# CITY OF ALBUQUERQUE

**Re: Red Rock Roasters, 4801 Jefferson NE,  
Traffic Circulation Layout  
Architect's Stamp dated 11-08-12 (F17-D096)**

Based upon the information provided in your submittal received 11-09-12, the above referenced plan cannot be approved for Building Permit until the following comments are addressed:

F-17/DO96

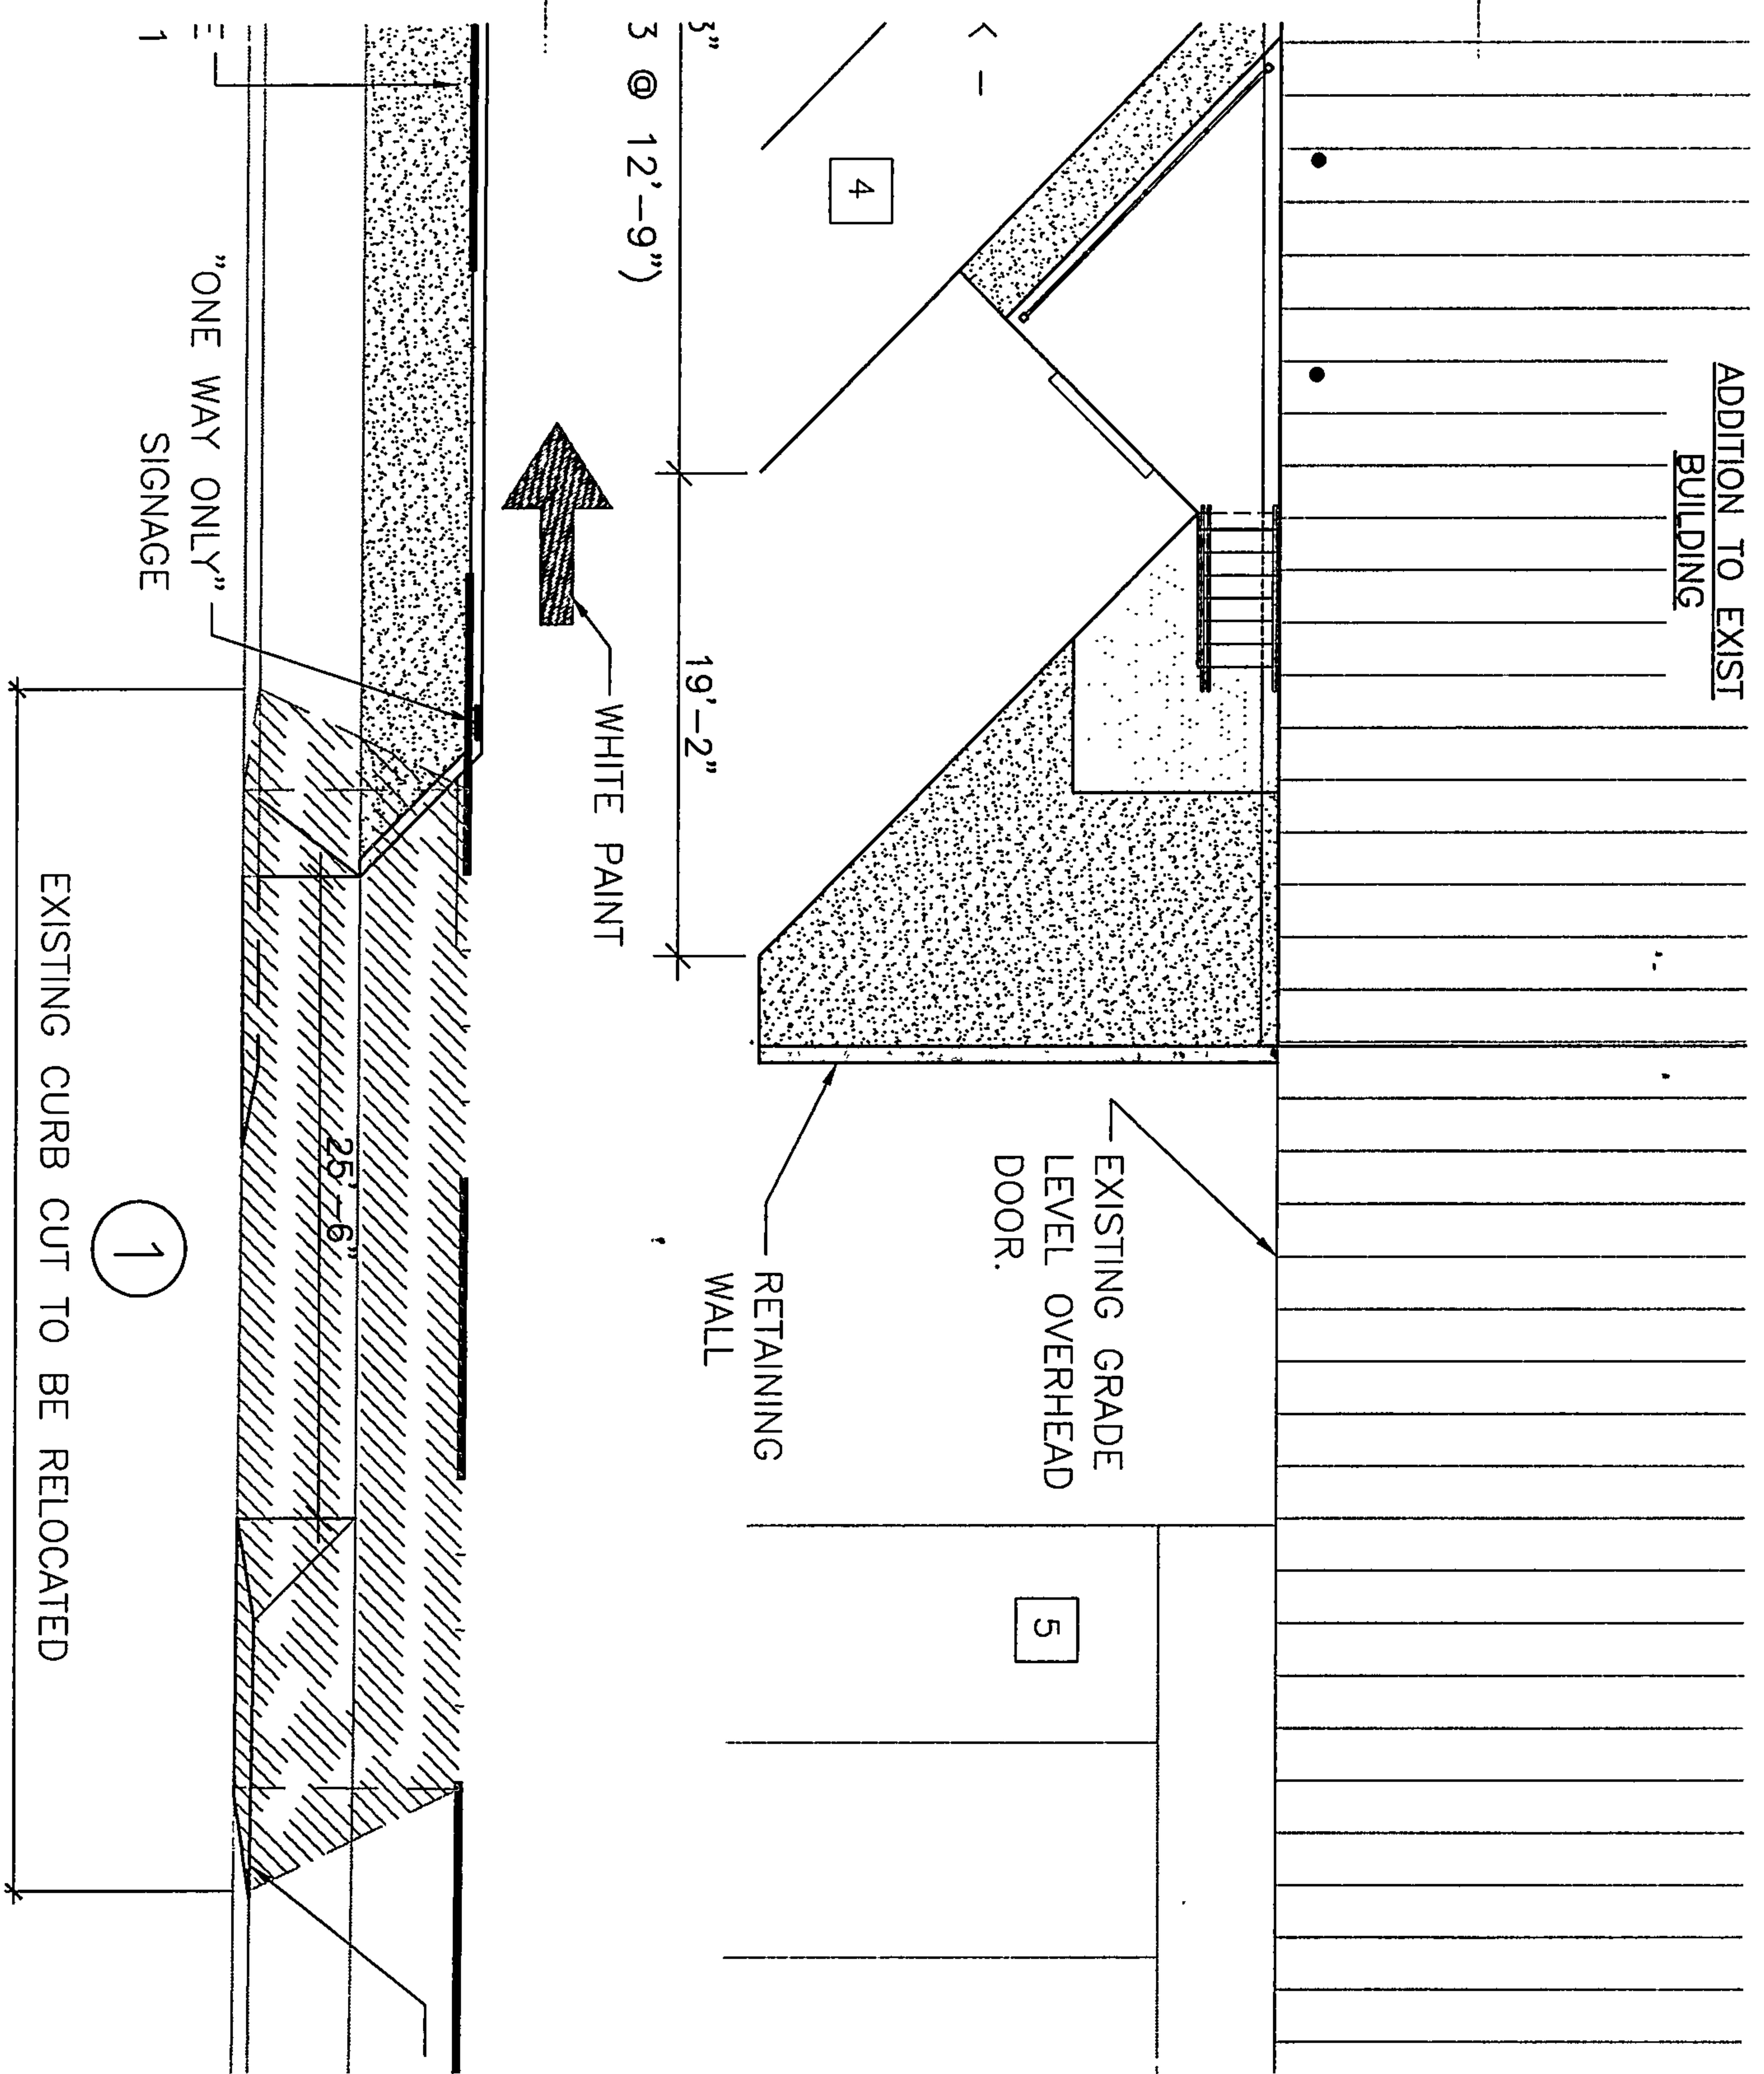
1. Please relocated all directional signage / striping to within the property line.
2. Per the *Development Process Manual*, Chapter 23, Section 7, Part A.6, "Curbing should be used to separate landscaping from parking areas and pedestrian ways."
3. Parking areas shall be paved with a minimum of 2 inches asphaltic concrete or equal. Additional detail for paving is not required.
4. The area south of the refuse bin should not be landscaped; please revise.
5. Please clearly show the limits of the existing drivepad versus the proposed drivepad. Refer to City Standard 2425.
6. Curbing along the landscape area should be located within the private property.
7. Please reference City of Albuquerque Standard Drawings for all proposed infrastructure on site.
